**Woolworths Warehouse and Distribution Centre Auburn (SSD-10470)
Response to Submissions**

Attachment A
The Department of Planning, Industry and Environment Issues

Heavy Vehicle Truck Route Plan

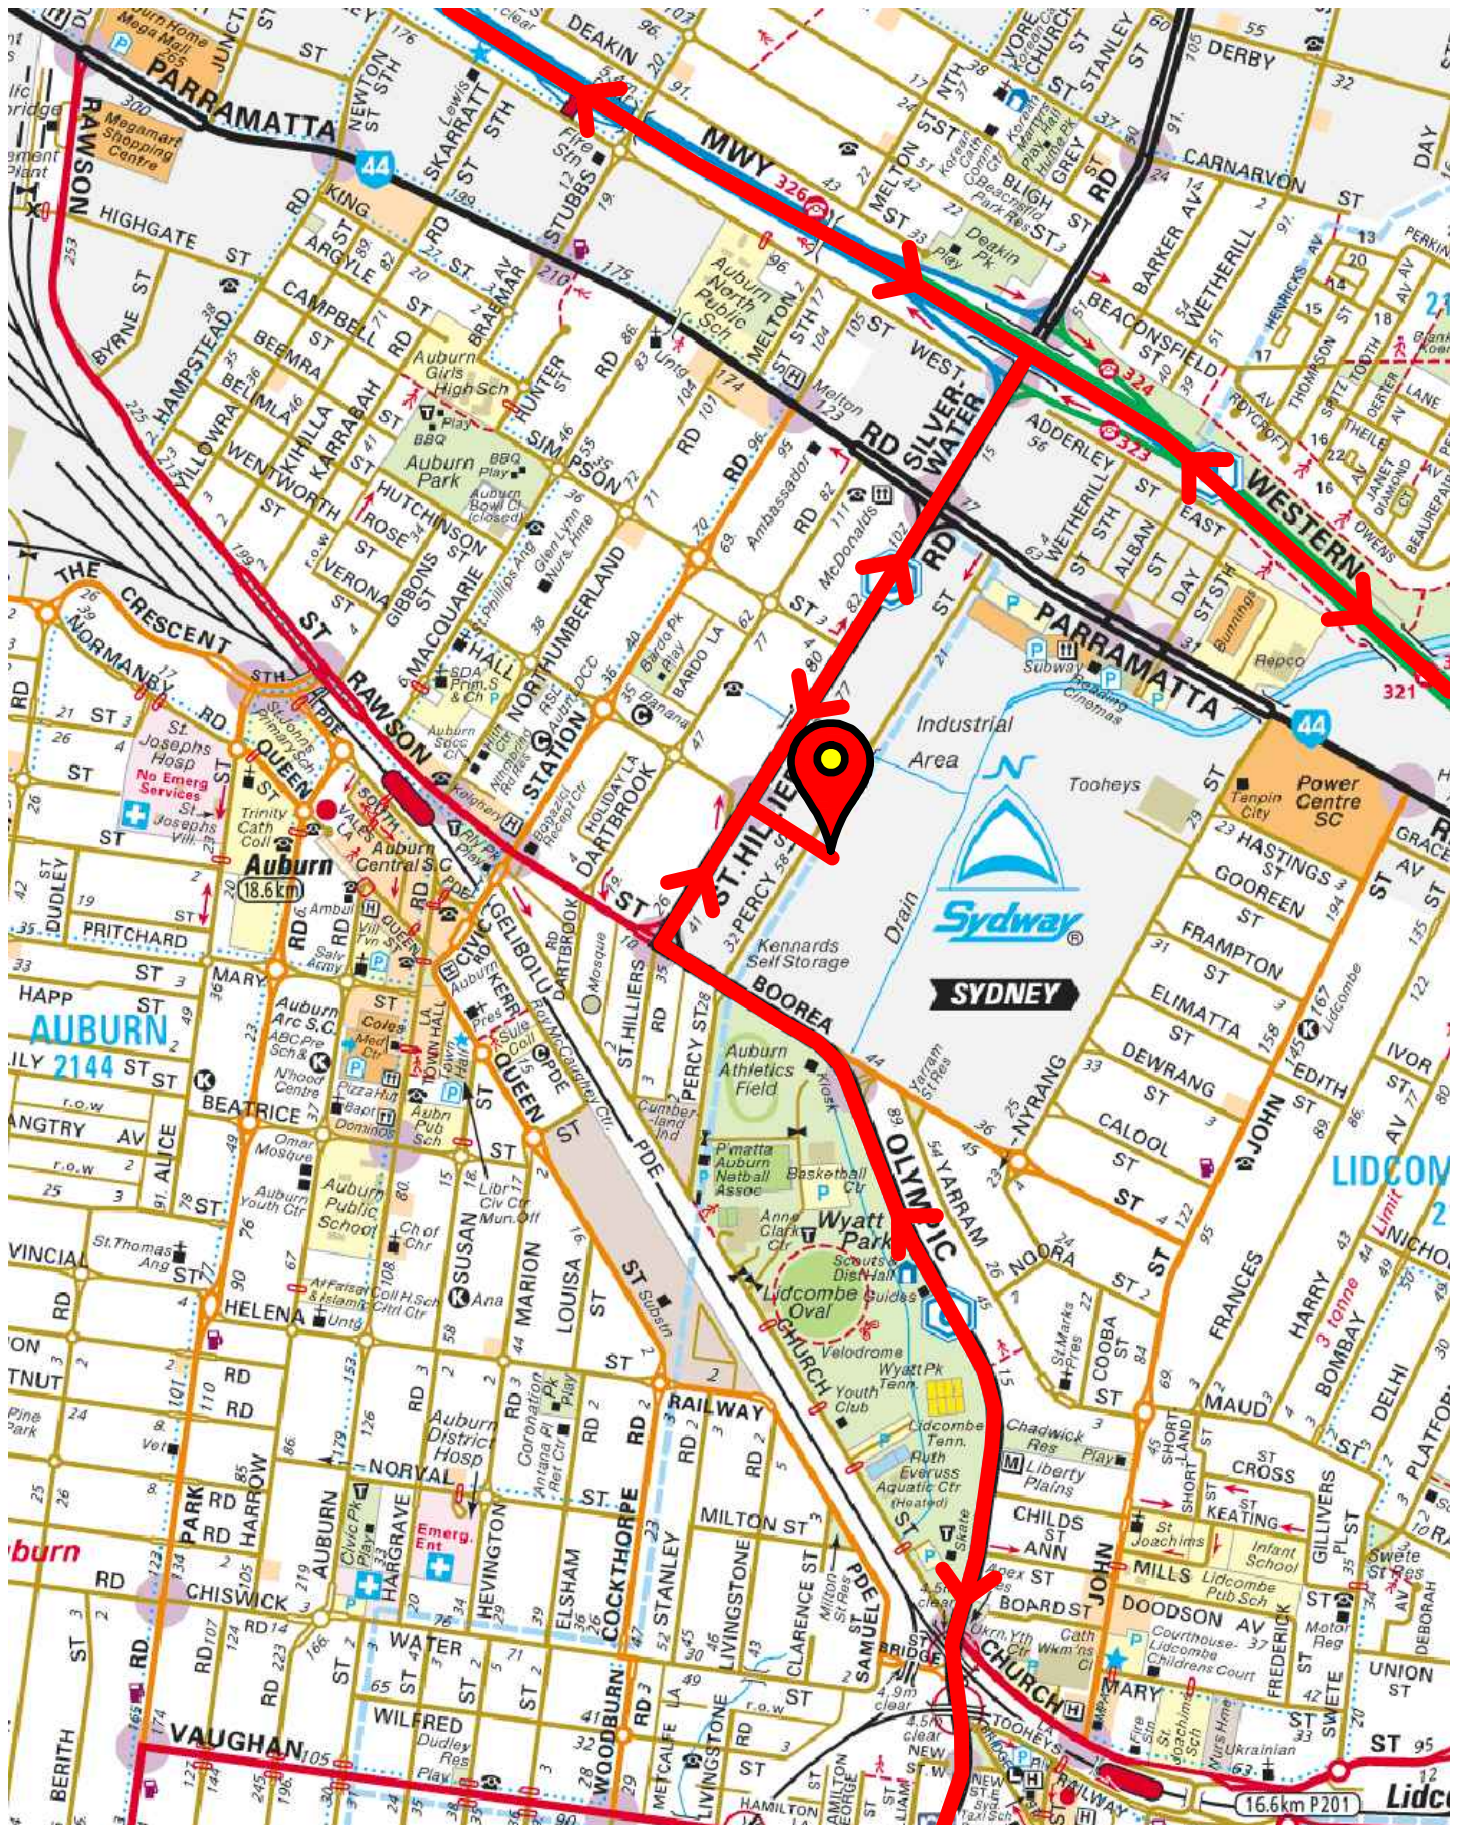
5. The development will increase heavy vehicular movements in the local area, potentially impacting the residential area to the north-west of the site. Please consider restricting truck movements to Percy Street, avoiding residential areas along St Hilliers Road. Such restrictions could be proposed through the implementation of a Driver Code of Conduct.

Figure 3-3: Class 3 SEPP 33 Distance

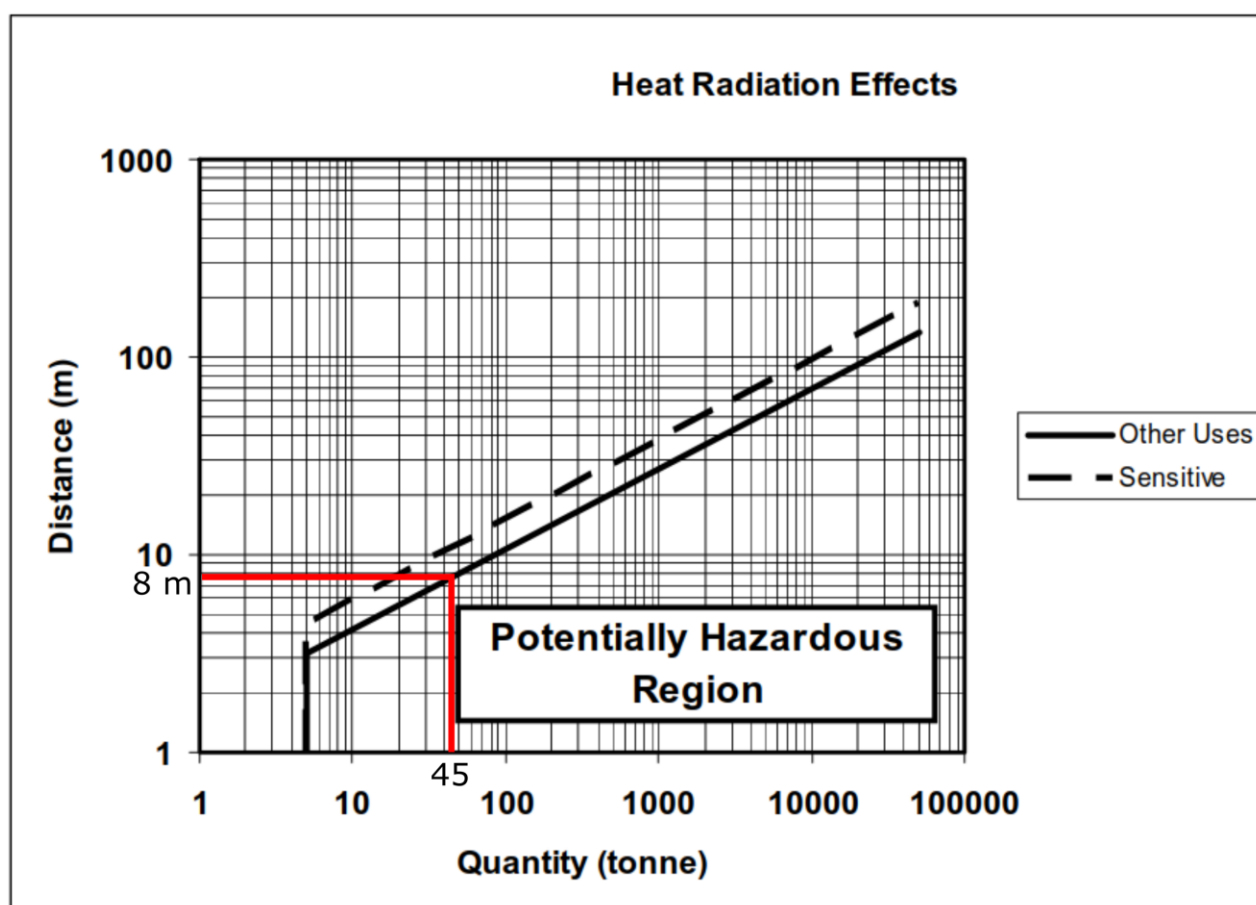
6. The EIS only indicated storage and handling of 45,000 kg of Class 3 (PGII and PGIII) and the report, *State Environmental Planning Policy No. 33* by Riskcon Section 3.1 states the site has “minimal quantities of DGs”. Based on a typical supermarket setting, there could be other DGs storage, for example from aerosol products or Class 8 materials. As such, please verify the amount of DGs to be stored on the site, including but not limited to, Class 2.1 (Aerosols) and Class 8, if any. If SEPP 33 is triggered, please prepare a Preliminary Hazard Analysis (PHA) which is to be submitted in accordance with Hazardous Industry Planning Advisory Paper No. 6, ‘Hazard Analysis’ and ‘Multi-Level Risk Assessment’.
